Plotted By: Acevedo, Elsie Sheet: Set-Kho Layout: C12.05 April 14, 2020 11:28:41am K:\067792503 - Addison Galaxy FBO\ACAD\Draws\Sheets\C12.00 DRAINAGE PLAN.dwg
 This document, together with the concepts and designs presented herein, is intended only for the specific purpose and client for which it was prepared. Reuse or improper reliance on this document without written authorization and adaptation by Kimley-Horn and Associates, Inc. shall be without liability to Kimley-Horn and Associates, Inc.

DATE	BY	NO.	REVISIONS	DATE	BY
04/14/2020	JM				
© 2019 KIMLEY-HORN AND ASSOCIATES, INC. 1400 WOODLICK FOREST DRIVE, SUITE 225 FORT WORTH, TEXAS 76104 PHONE: 817-475-2816 TBP# FIRM REGISTRATION F-928 WWW.KIMLEY-HORN.COM					
KHA PROJECT	DATE	SCALE	DESIGNED BY	DRAWN BY	CHECKED BY
067792503	2/21/2020	AS SHOWN	HCV	EAC	HCV
<h3>STORM DRAINAGE PLAN SD-2 AND 3</h3>					
ADDISON GALAXY FBO 15601 ADDISON RD. PREPARED FOR BLACK FOREST VENTURE					
DALLAS, TEXAS					
SHEET NUMBER <h2 style="margin: 0;">C12.05</h2>

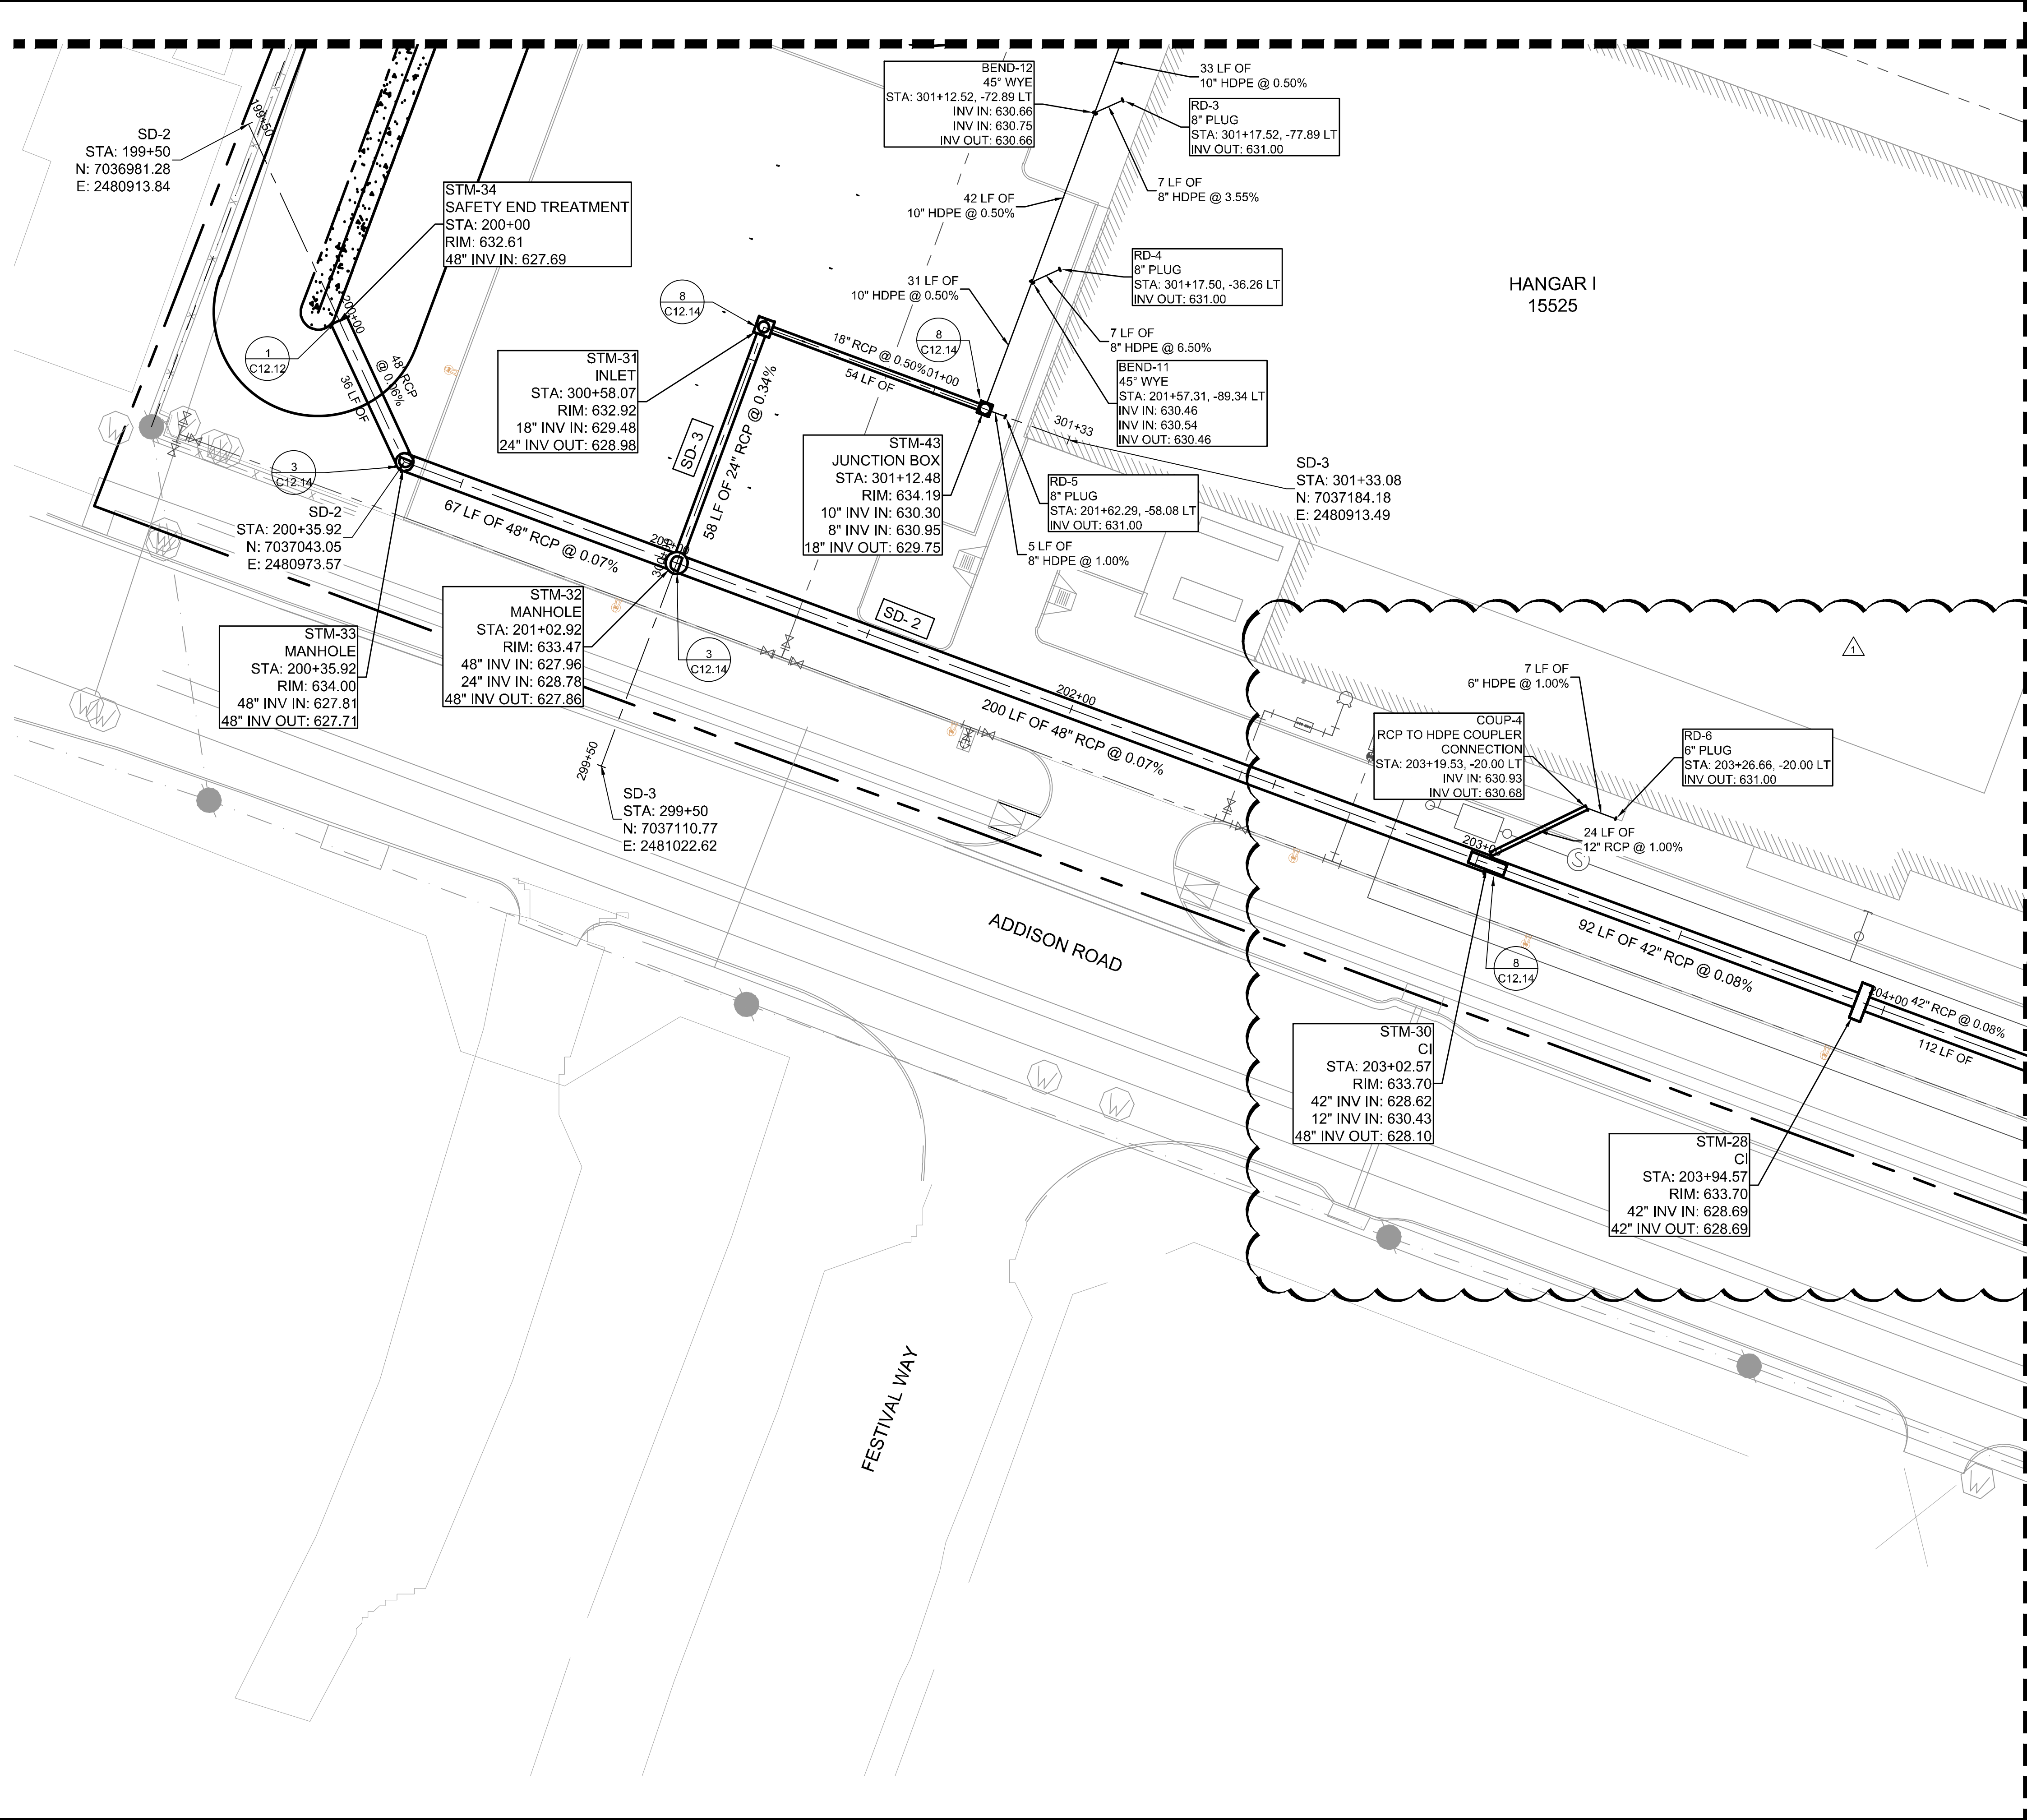
This looks like it's going to be an issue. Please find a better way to configure this
